**WELWYN HATFIELD BOROUGH COUNCIL  
EXECUTIVE DIRECTOR - PLANNING, PUBLIC PROTECTION AND GOVERNANCE**

**DELEGATED APPLICATION**

**Application No:** 6/2018/0383/FULL  
**Location:** 8 Hill Rise Cuffley Potters Bar EN6 4EE  
**Proposal:** Erection of a three storey detached house with a raised patio following demolition of existing dwelling  
**Officer:** Mr David Elmore

Project Address	8 Hill Rise, Potters Bar, EN6 4EE
Sheet Title	Proposed Site 3D Views
Sheet Number	A108
Revision	
Issue Date	29/01/2018

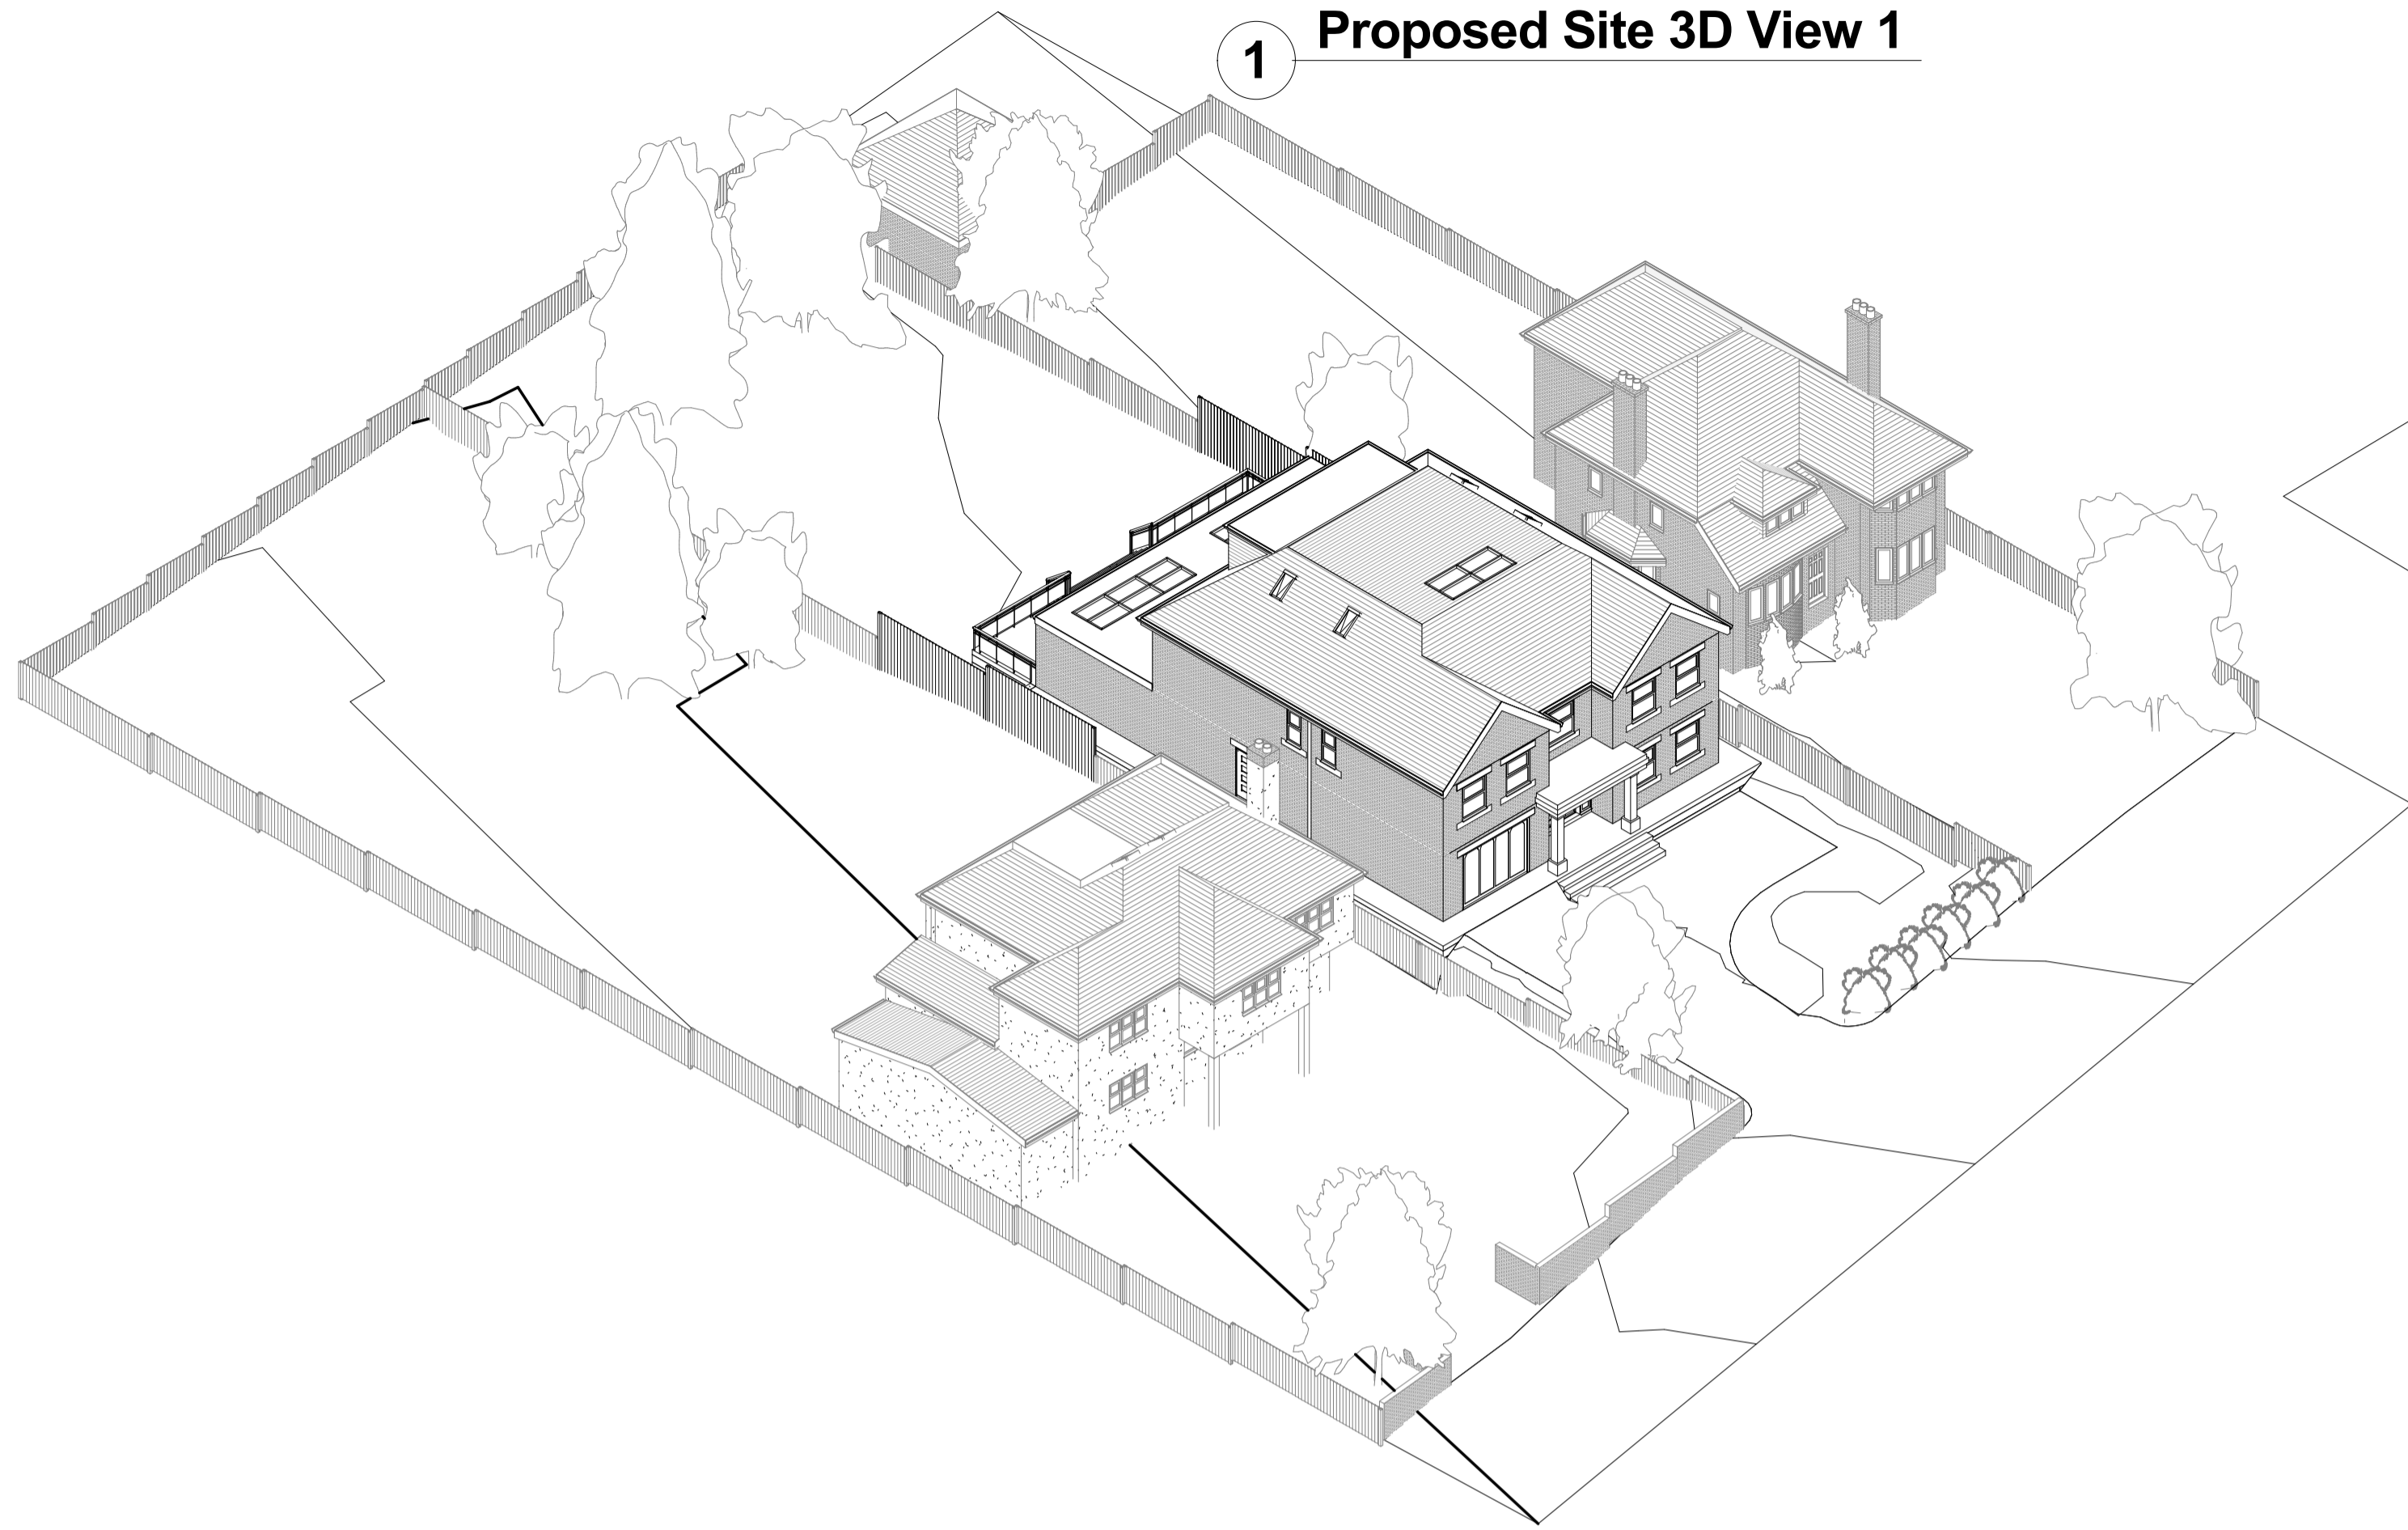
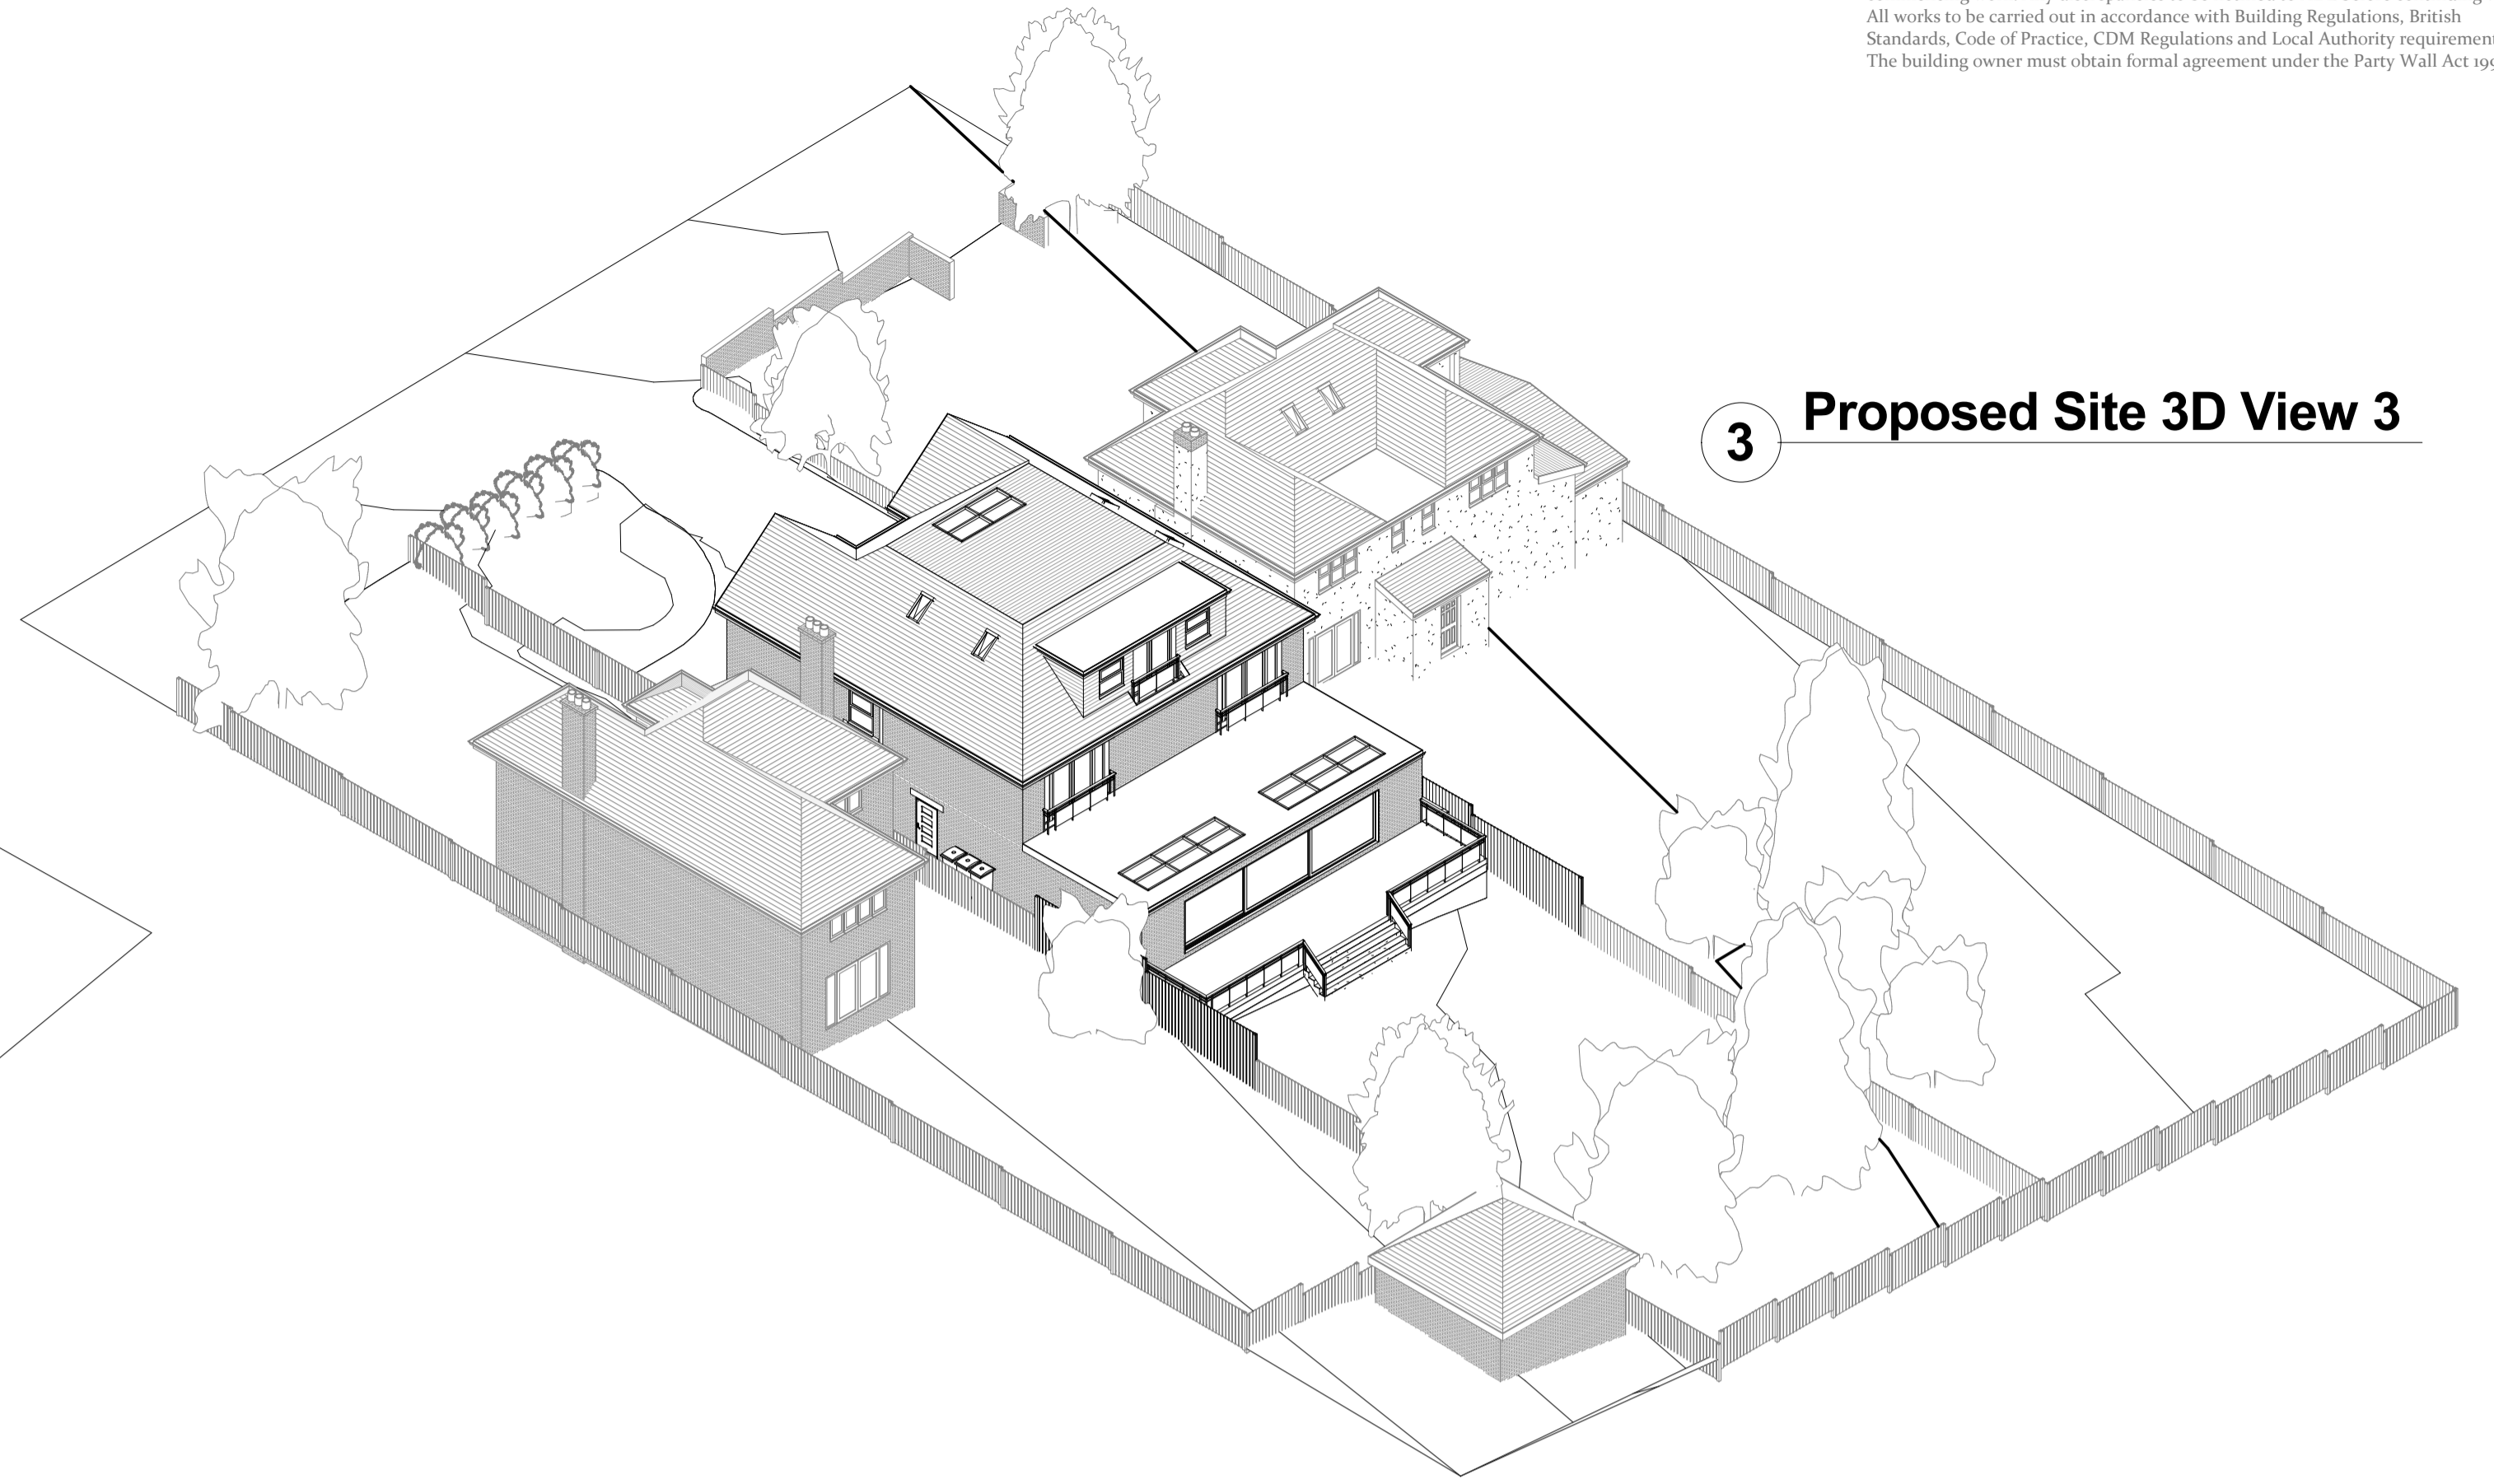
**Comment:** The proposed site 3D views appears to illustrate that the existing front driveway would be retained, however this is not clear.

The proposed dwelling would serve 5 bedrooms. A 5-bed dwelling in location is expected to accommodate a guideline level of 3 off-street car parking spaces having regard to the Council's SPG and Interim Parking Policy. The existing driveway could practically accommodate two cars and the proposed dwelling features an integral garage for one car. In any event, the extent of hard

landscaping will have to be agreed via a planning condition. On this basis, it is considered that a sensible level of parking provision would be achieved, in accordance with both local and national planning policy.
